Appeal Decision

Appeal Ref: APP/R5510/D/24/3358043

107 Woodlands Avenue, Ruislip HA4 9RB

- The appeal is made under section 78 of the Town and Country Planning Act 1990 (as amended) against a refusal to grant planning permission.
- The appeal is made by Mr J Mulchandani against the decision of the Council of the London Borough of Hillingdon.
- The application Ref is 52182/APP/2024/2207.
- The proposal is a two storey side extension.

Drawing No.
24/3088/01

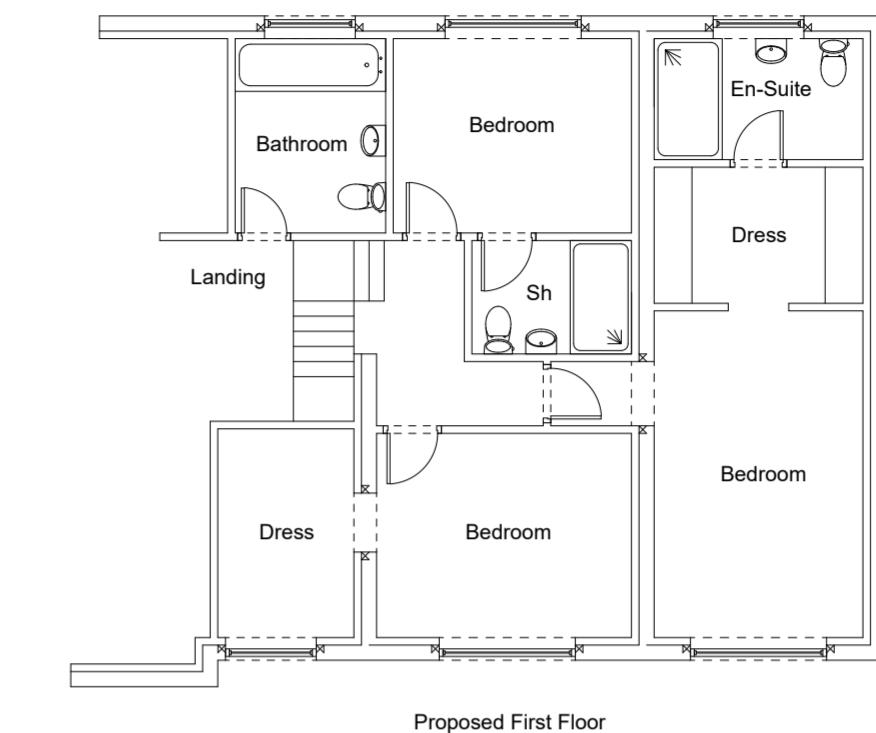
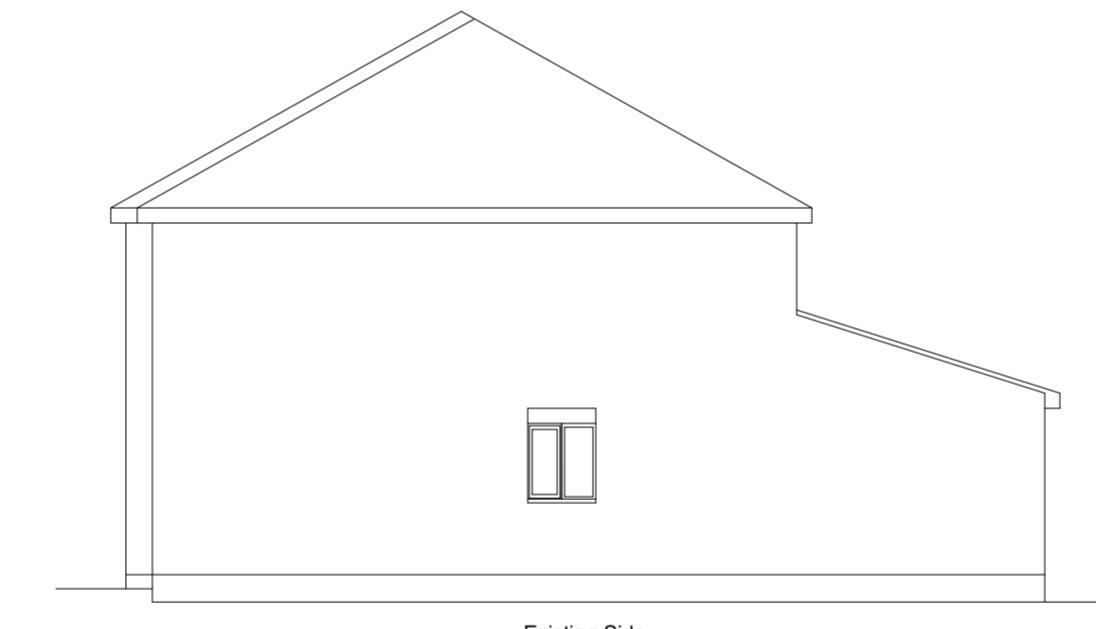
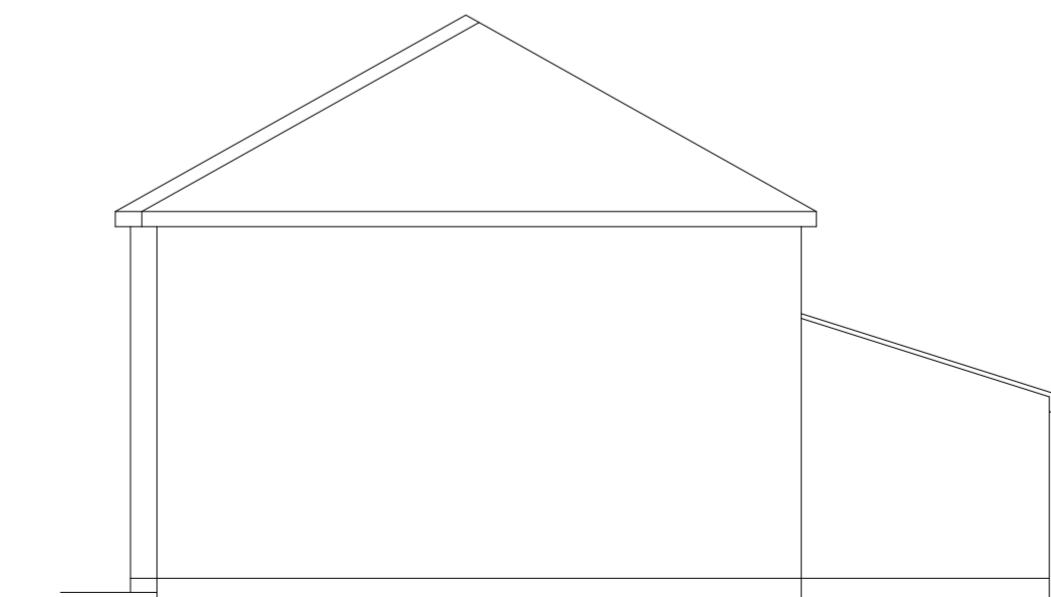
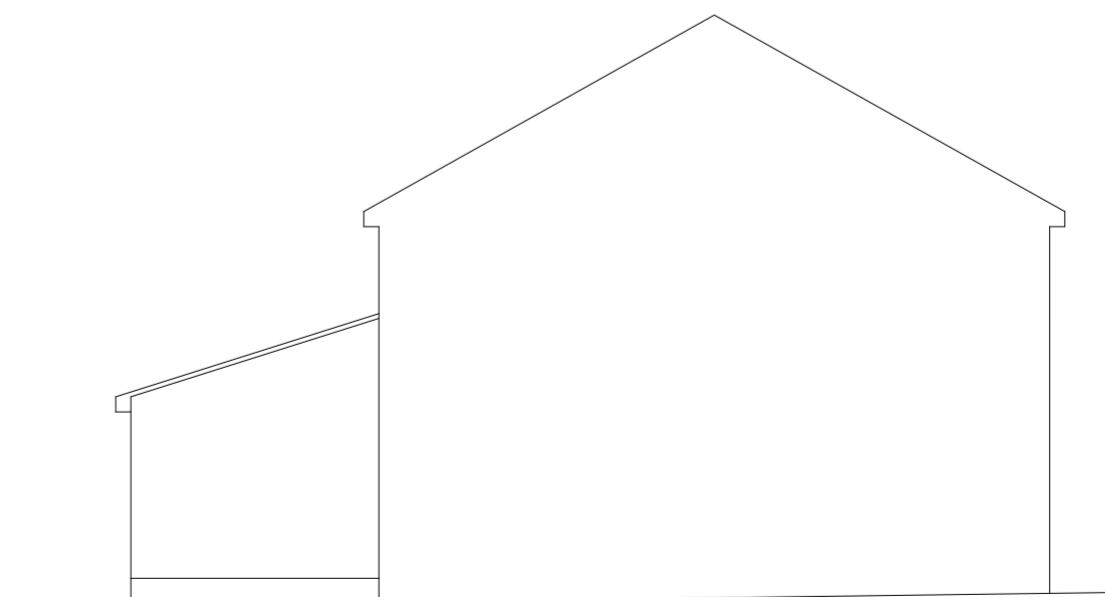
5. The proposal would conflict with several specific requirements of Policy DMHD 1 of the London Borough of Hillingdon Local Plan Part 2 - Development Management Policies (2020) (DMP). Firstly, the cumulative extensions would substantially exceed half the width of the original dwelling. Due to the extension's two-storey scale and even with the use of matching materials and the replication of the fenestration pattern, this would give the host dwelling a markedly elongated appearance, emphasising the disparity in width between the host dwelling and its

counterpart at No 105. This would be further exacerbated by the absence of a reduction in ridge height or, as required by DMHD 1, a set back from the main front elevation.

Drawing No.  
24/3088/05

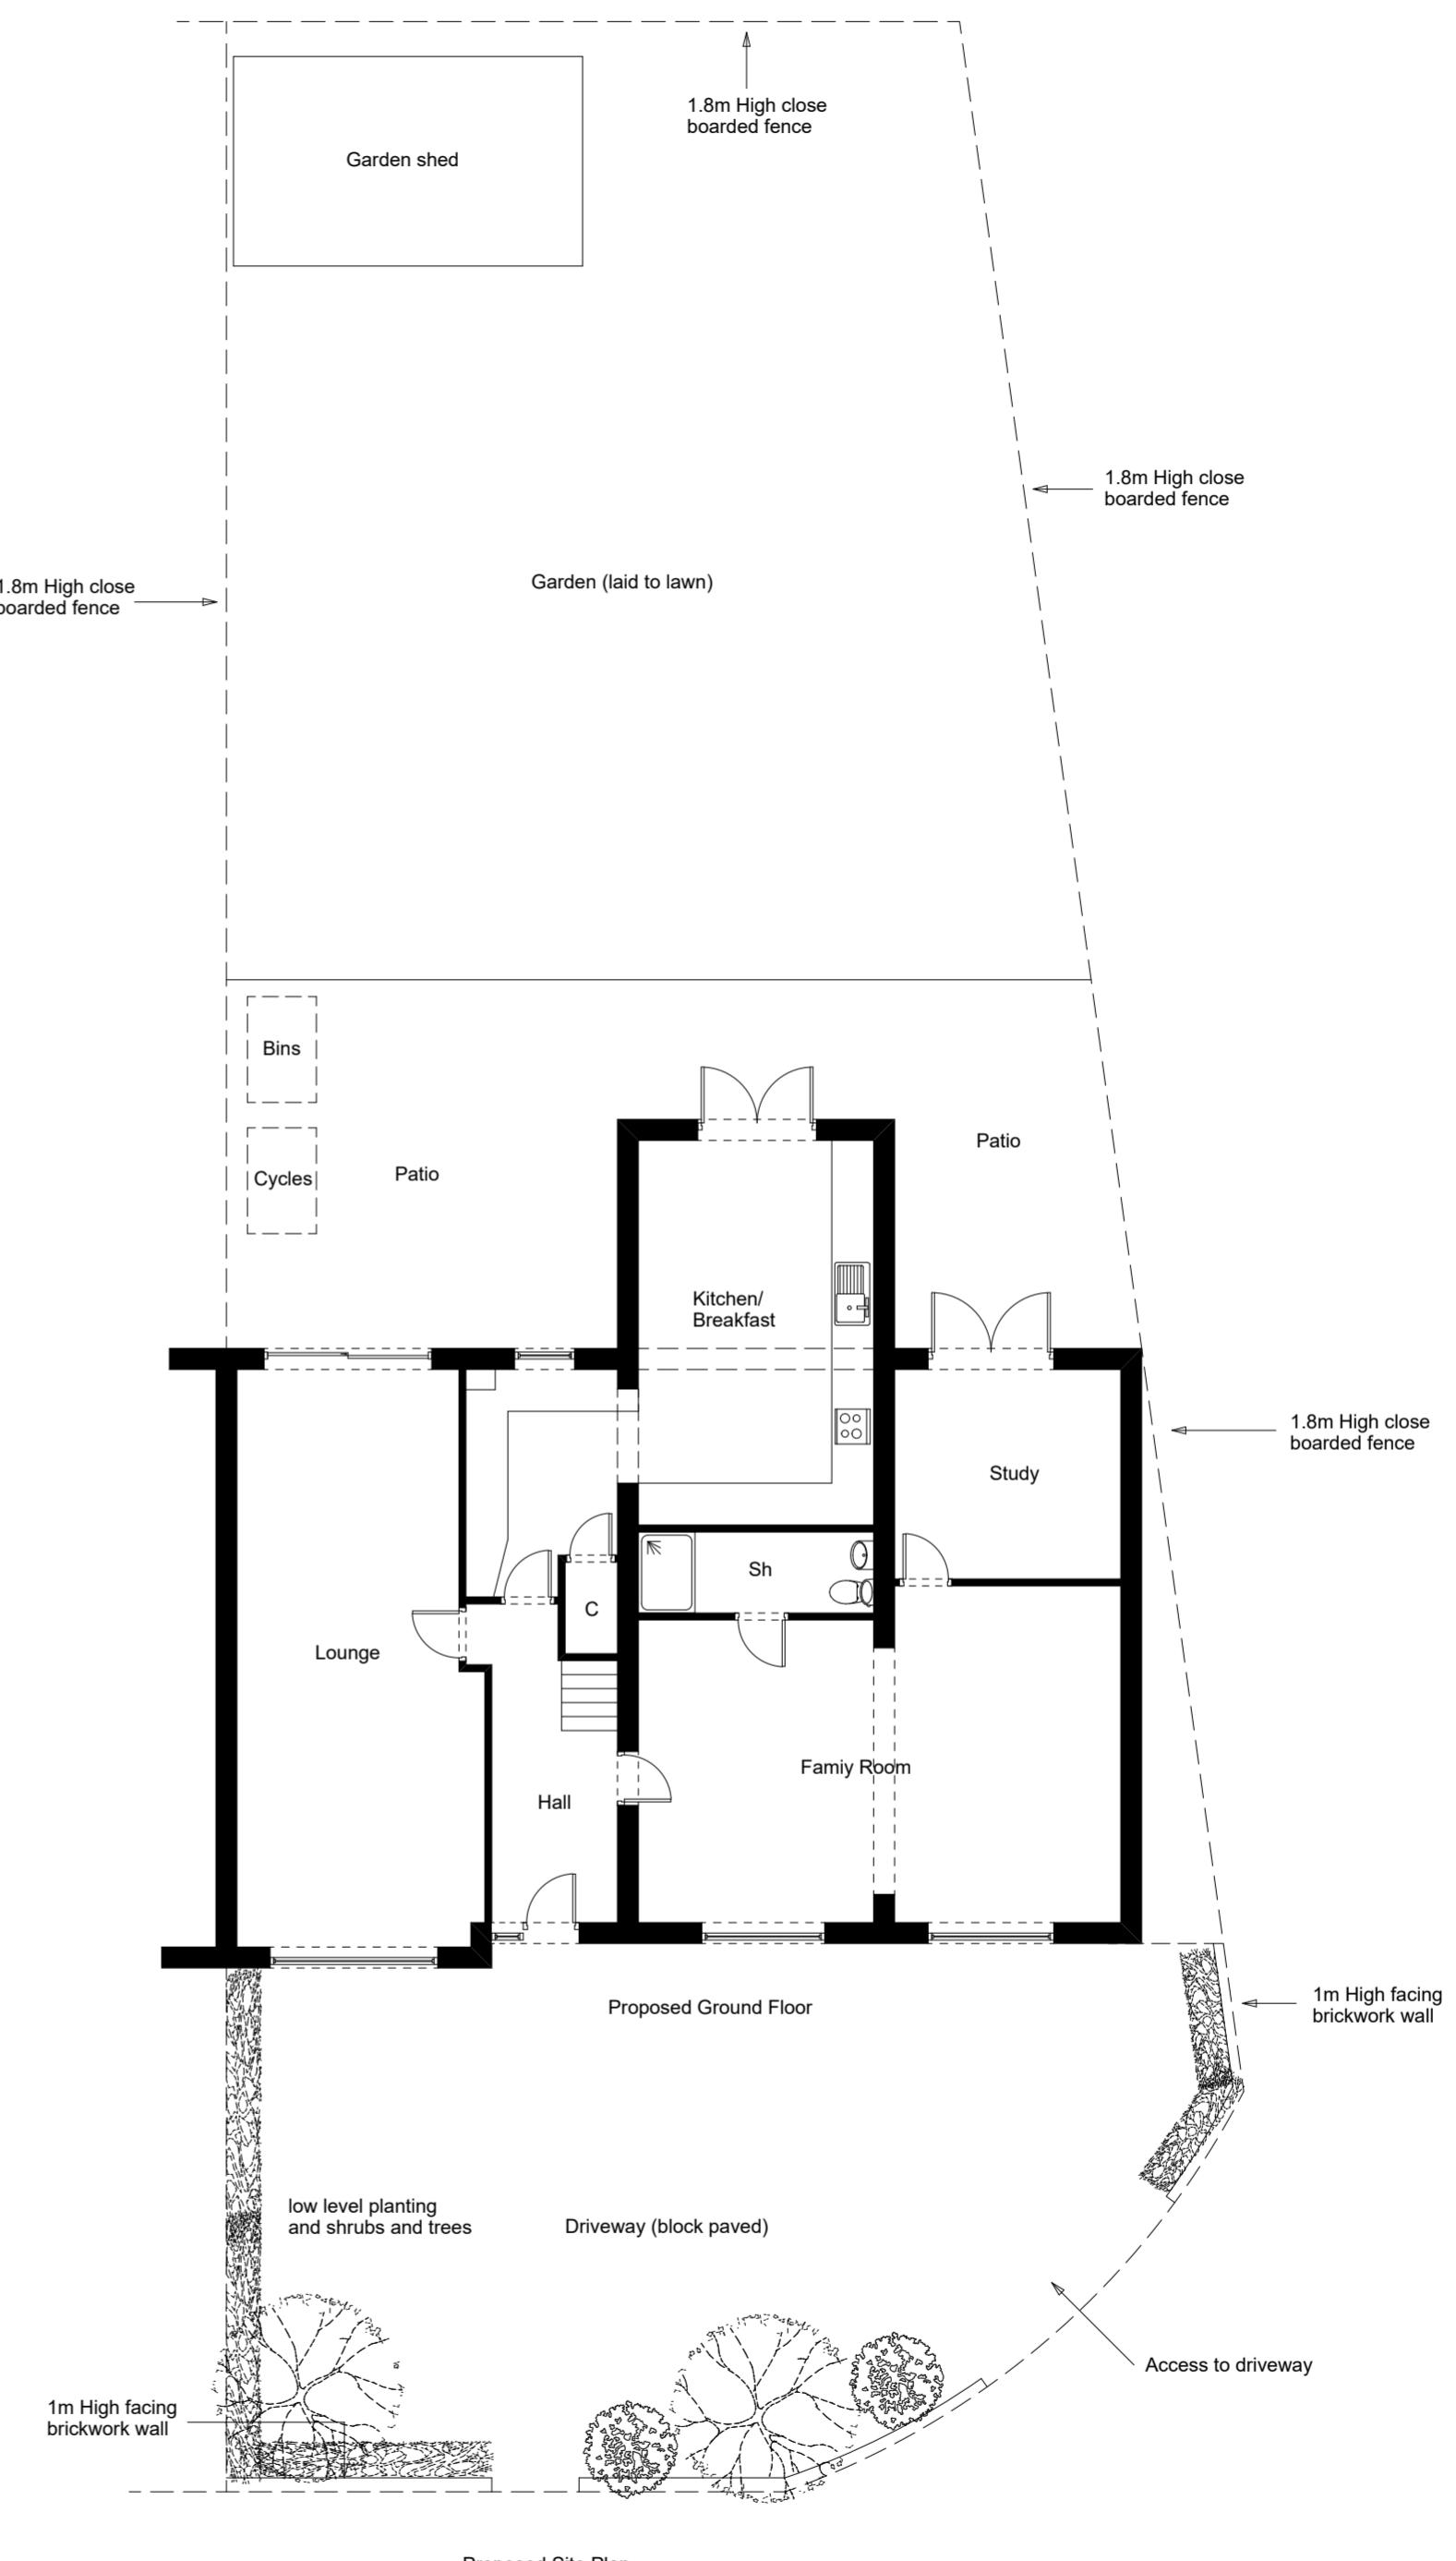
6. Furthermore, the extension would significantly exceed the return building line on Warren Drive and, even accounting for the tapered alignment of the side boundary, would only incorporate a narrow gap to the boundary. This would unacceptably diminish the sense of openness at the corner, appearing unduly dominant and cramped, compounding the conflict with the requirements of Policy DMHD 1.
